Application No: AB/135/20/OUT

Site Address: Land at Ford Road Arundel

Description of works: Outline application with some matters reserved (except for access) for the development of 90 dwellings & associated amenity land. This application is a Departure from the Development Plan, affects the setting of listed buildings & affects the character & appearance of the Arundel Conservation Area.

Parameter Plan - Movement

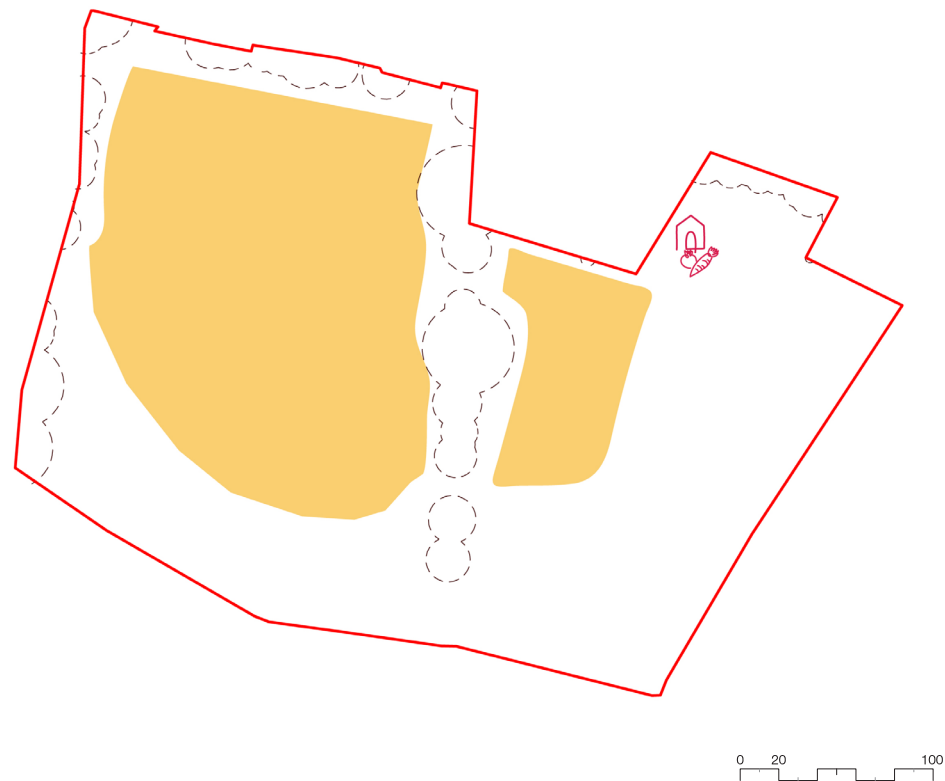
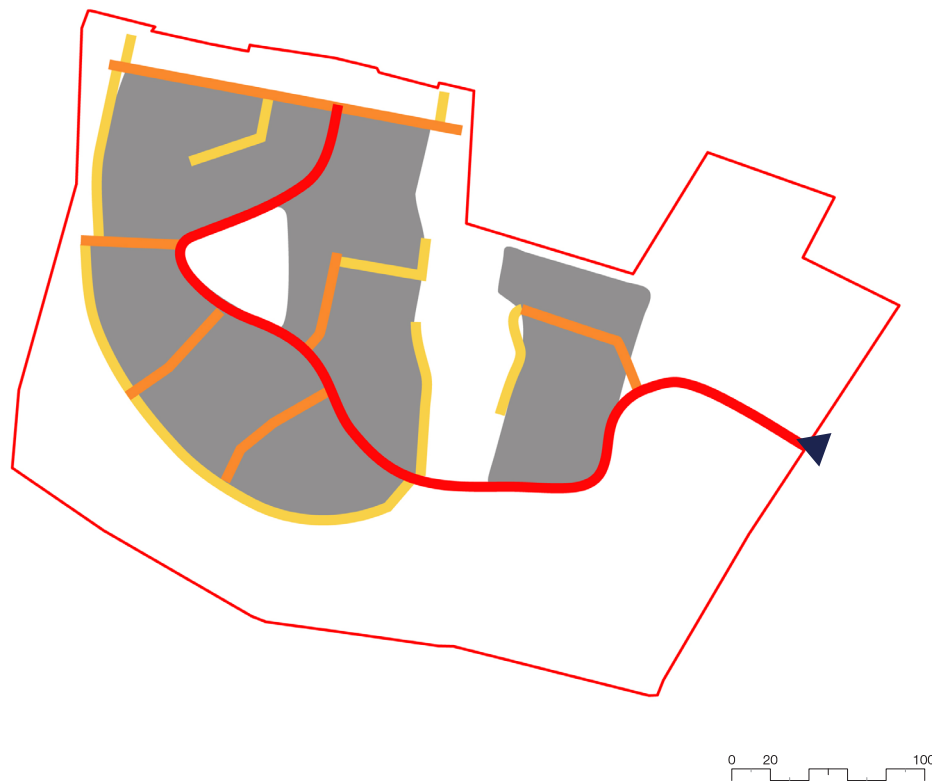
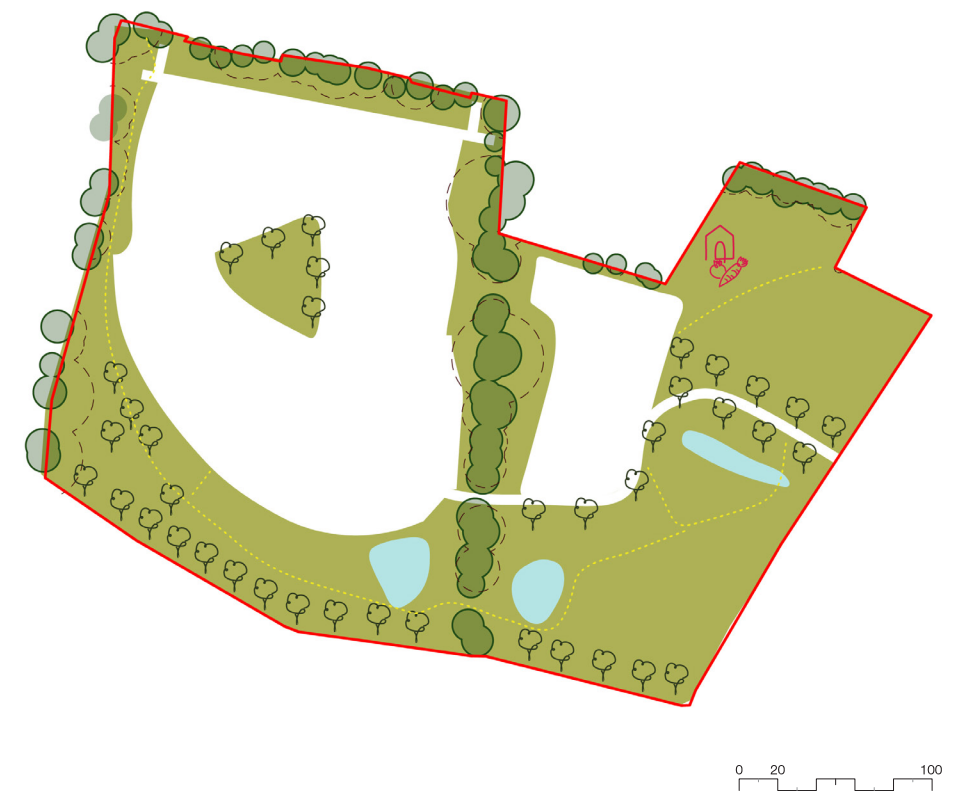
The plans included in this application are different to those shared as part of the initial consultation. The initial plan showed Dalloway Rd as an emergency only access point, this is not shown on the plans submitted here. If this is to be the case I object to the plans. Having this as an access point to the new development will change the nature of the local quiet roads. It will turn Torton hill Road, Dalloway Road and Maxwell Road into another dangerous rat run. These roads are all used by local families to walk children to school and increased traffic would be detrimental to their health and safety.
